AW-178-11 - 15 Kingsway - Objection 1-9-2011

OBJECTION TO: AW/178/11 - demolition and building extensions 15 Kingsway,
Craigweil House Conservation Area

Elevations as proposed

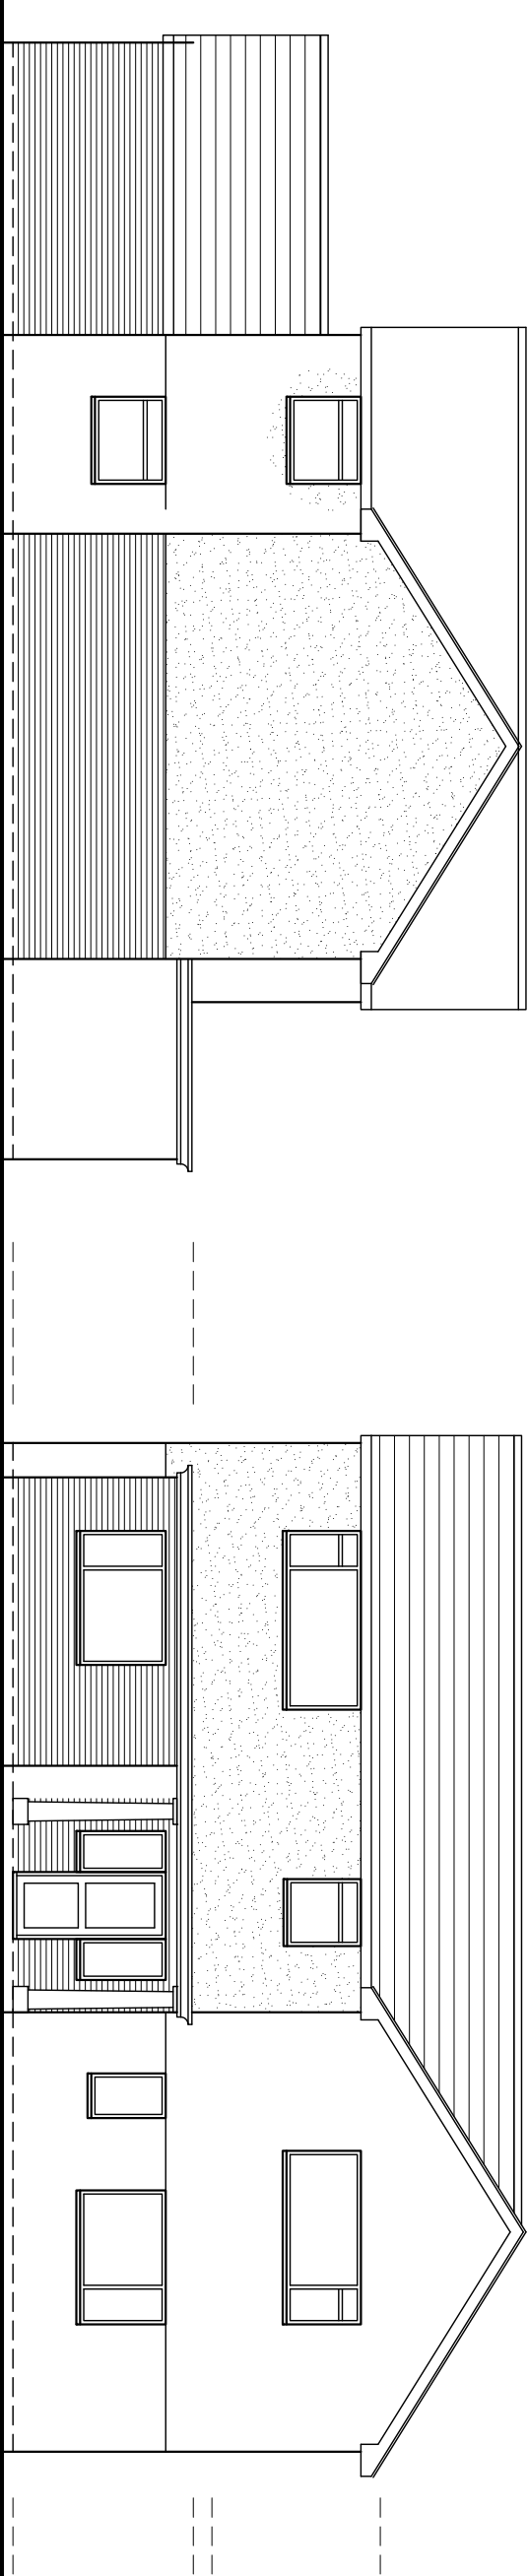
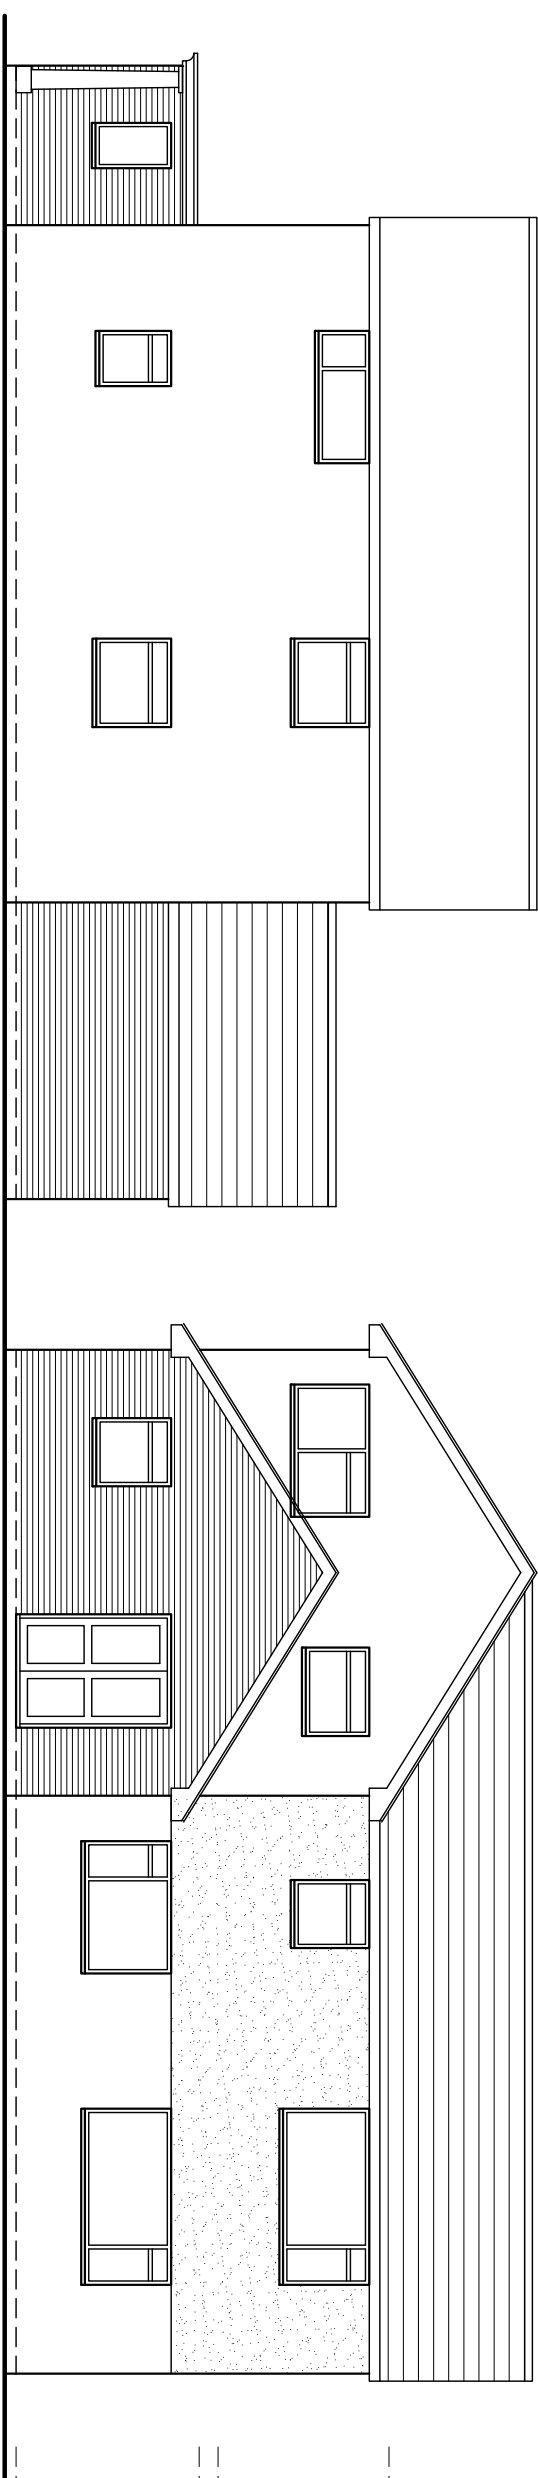
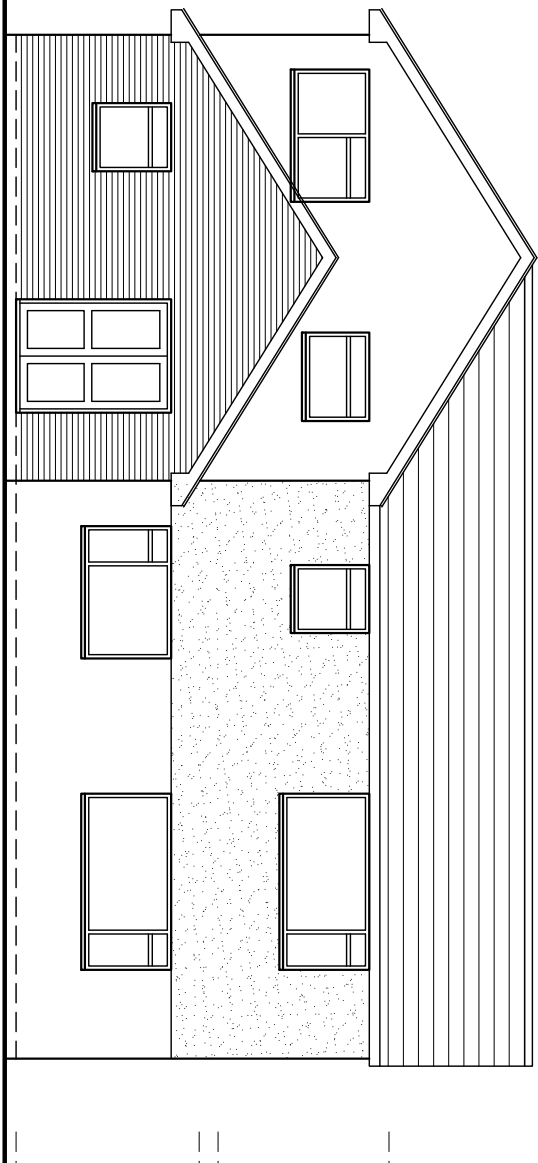
This application involves forward extension and we object to this for No. 15 has a short front garden and any further erosion of it by an extension will undoubtedly be damaging to the established street scene and the character of the area.

Ground floor

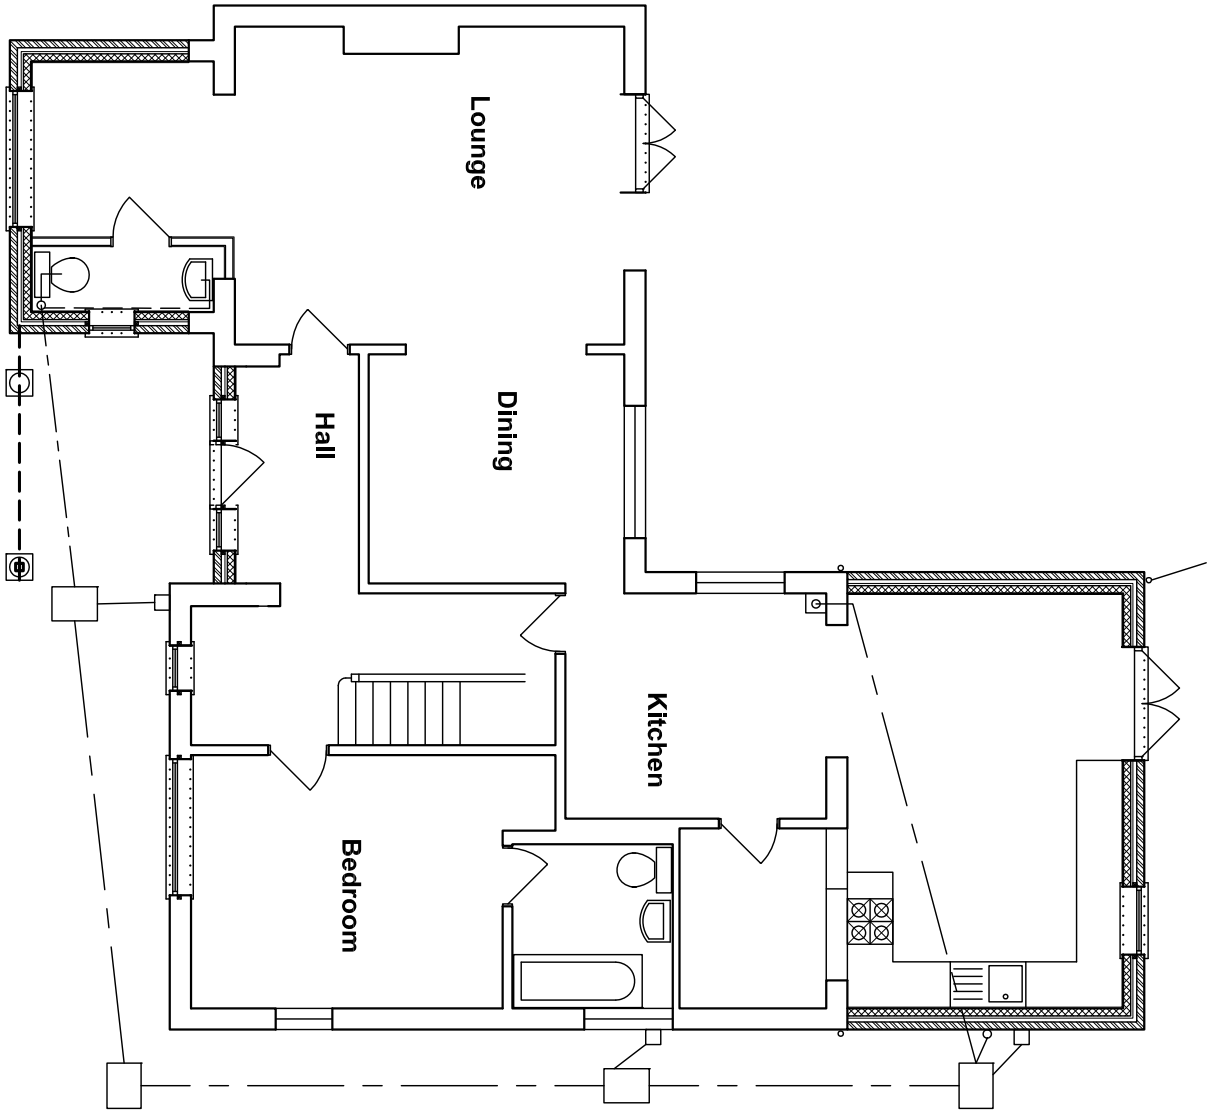
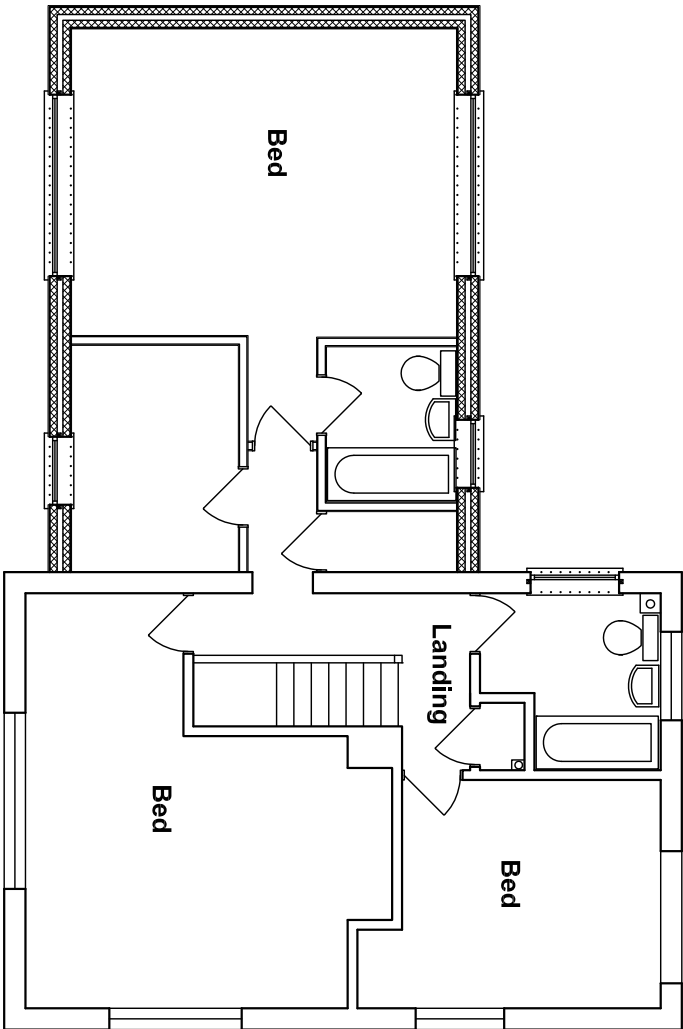
The removal of the existing garage will involve the use of a digger, lorries and other major plant, without doubt, to remove footings and ground slab within a very restricted area. We are concerned that, during this operation, work is likely to be within the Root Protection Area of trees within the grounds of No. 15 or the adjacent property and that trees may be damaged or killed. We ask that special attention be paid to the protection of all trees according to BS 5837:2005 - 'Trees in relation to construction - Recommendation'. We respectfully mention that a 'Recommendation' is higher in strength than the normal British Standard that is merely advisory. Without a Method Statement explaining how trees will be protected, we must object to this application.
